Phone: 0300 123 6780  
Email: [developeras@lancashire.gov.uk](mailto:developeras@lancashire.gov.uk)  
Your ref: 3/2023/0141  
Our ref: D3.2023.0141  
Date: 17 July 2023

Application no: **3/2023/0141**

Address: **6 Tintern Close, Simonstone BB12 7SS**

Proposal: **2 Storey side and rear extension, dormer and rooflights added to side elevatin, single storey extension to side and rear, balcony to rear and external works to create raised terrace areas and erection of detached garden house.**

Job Number	Description	Rev
A	Proposed Site Plan

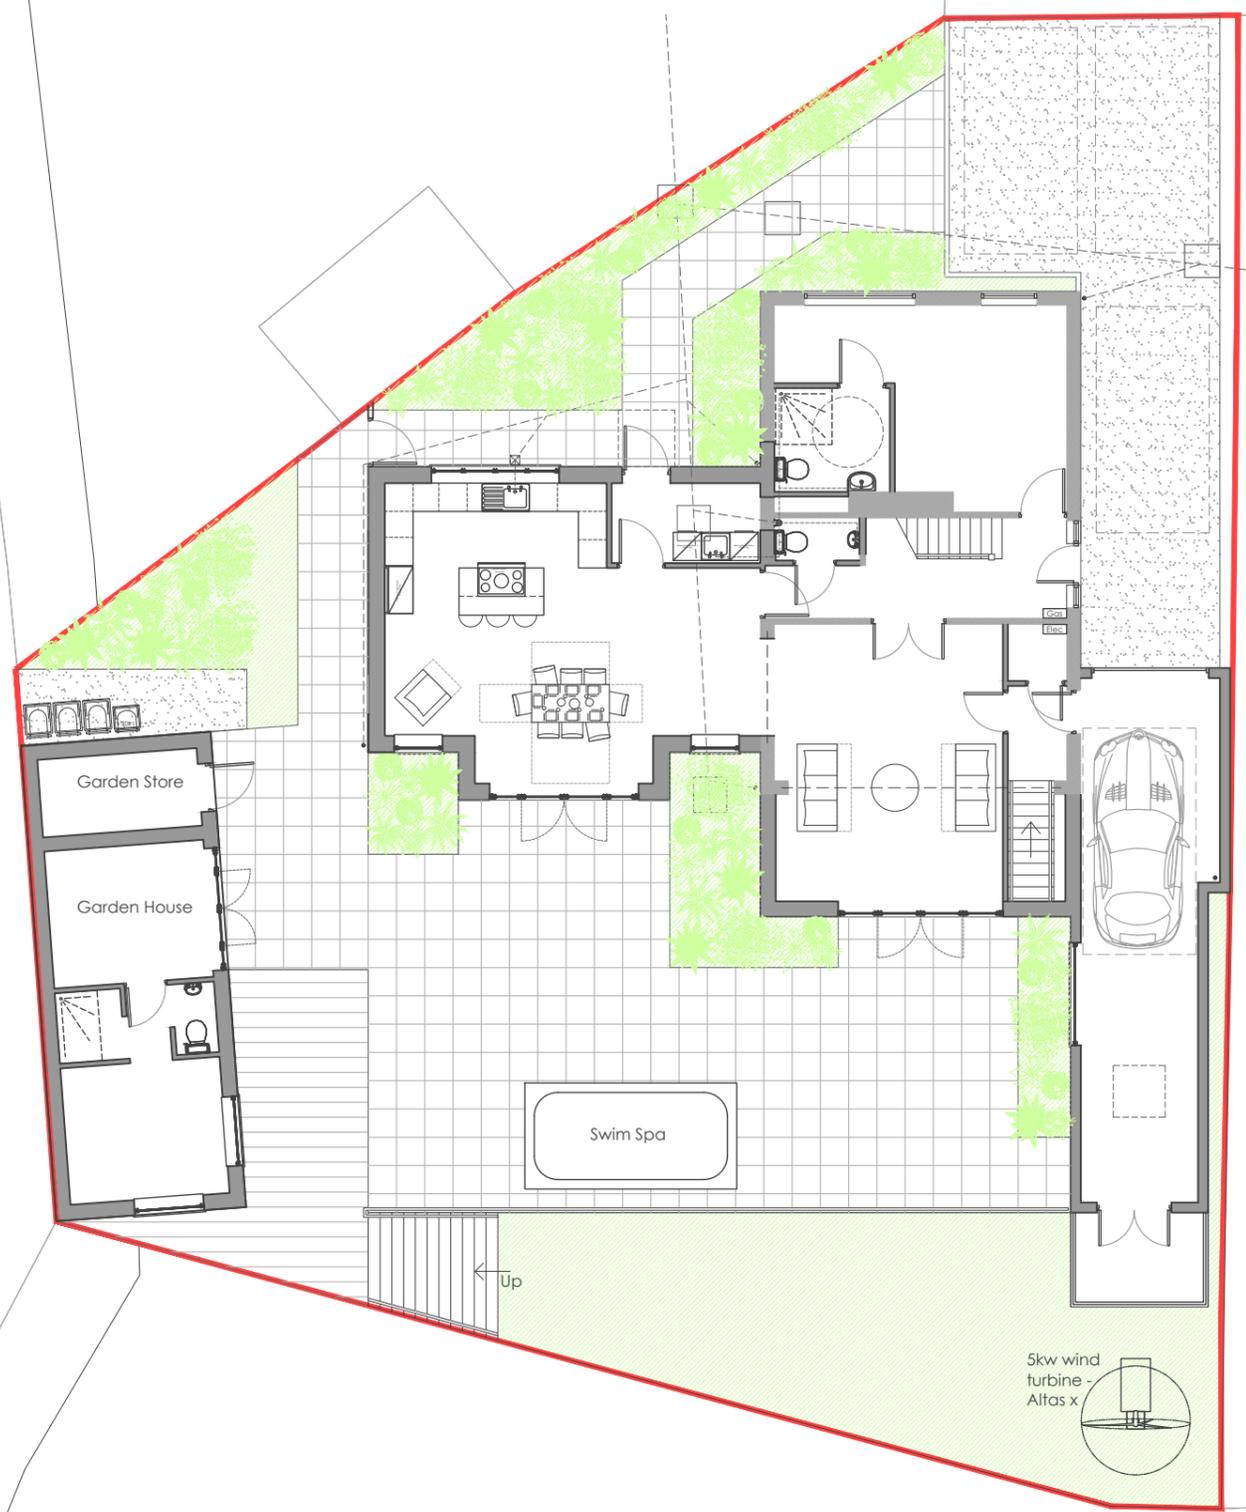
Having considered the information submitted, the above proposal raises no highway concerns. The 3 parking spaces required by parking standards can be achieved within the curtilage of the property. Therefore, the Highway Development Control Section would raise no objection to the proposal on highway safety grounds.

Parking on a turning head is not acceptable for highway safety reasons.

- The parking areas must be constructed of a bound porous material and created before first occupation up until the lifetime of the dwellings existing in their proposed state. Reason: To ensure that satisfactory parking is provided before the dwelling hereby permitted becomes operative.
